**AIRLY MINE EXTENSION PROJECT – STATE SIGNIFICANT DEVELOPMENT 5581
ENVIRONMENTAL IMPACT STATEMENT – EPA ASSESSMENT**

I refer to the Environmental Impact Statement (EIS) for the Airly Mine Extension Project (SSD 5581) provided to the Environment Protection Authority (EPA) on the 22 September 2014 requesting comments on the development application and advice on recommended conditions of approval by Friday 31 October 2014.

Attachment A: EPA comments and recommended conditions of project approval for the Airly Mine Extension Project.

**Figure 3.3:
Water Management
Schematic**

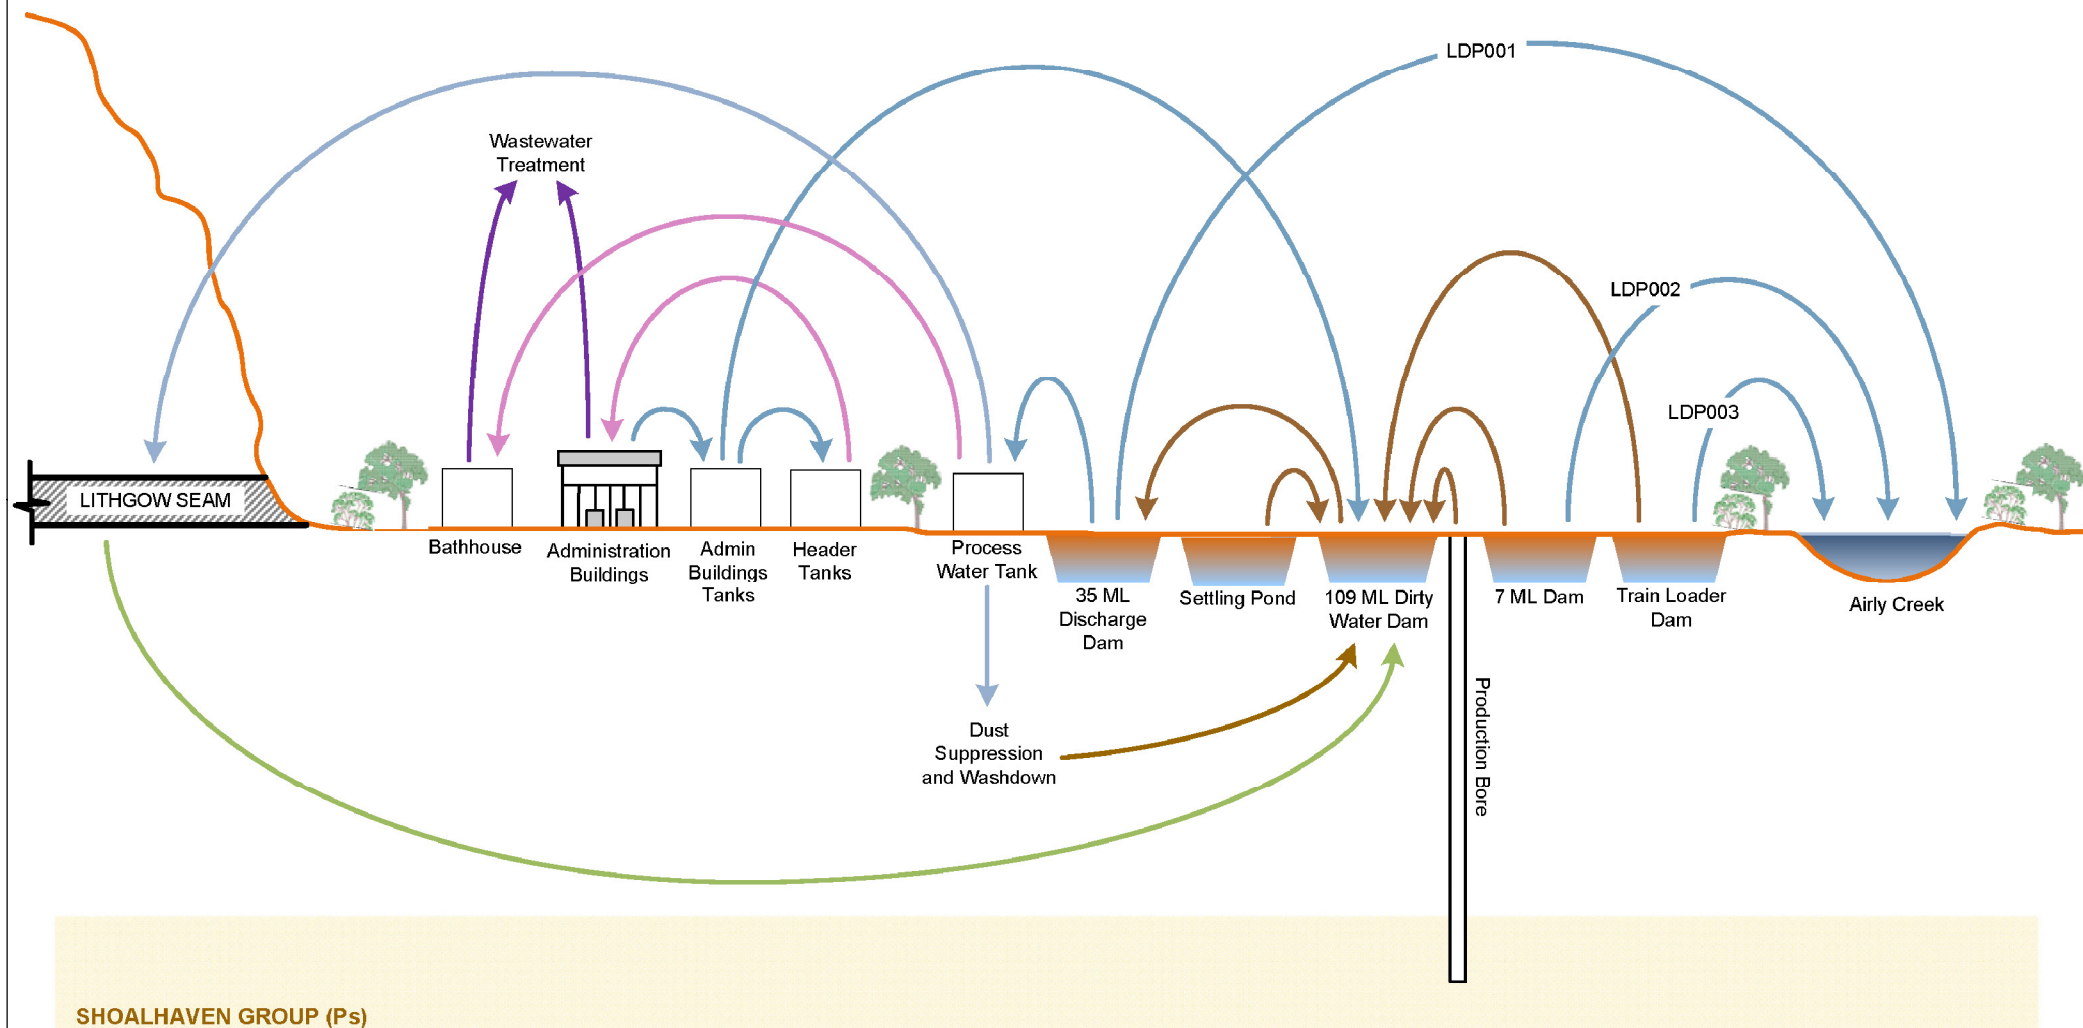
The EPA notes in the Summary of the Environmental Impacts – Overview of Key Findings on page IV of Volume 1: Report of the EIS, the following is stated in relation to increased discharges through the existing LDP001 "Airly Creek is predicted to experience a maximum cumulative increase of 14.5% in flow".

However, on page 3 in the Executive Summary – Appendix F of the Surface Water Impact Assessment reference is made to a change in waterway flow of 1% in Airly Creek. **The EPA is therefore seeking clarification of the likely increase to flow in Airly Creek due to mine activities related to LDP001.**

For each monitoring/discharge point or utilisation area specified in the table provided (by a point number/description), the concentration of a pollutant discharged at that point, or applied to that area, must not exceed the concentration limits specified for that pollutant in the table.

Point: Licensed Discharge Point (LDP) for water from the Reject Emplacement Area (REA).

Pollutant	Units of Measure	100 percentile concentrations limit
pH	pH	6.5–9.0
TSS	milligrams per litre	50 mg/L
Oil and grease	milligrams per litre	10 mg/L

The concentrations limits stipulated in the table above are deemed not to apply when the discharge from the stormwater control structure (sediment basin) occurs solely as a result of rainfall measured at the premise which exceeds the design storage capacity of the sediment basin.

The stormwater control structure (sediment basin) identified above must be drained or pumped out following rainfall as necessary (in accordance with the discharge concentration limits) to maintain the basins design storage capacity.
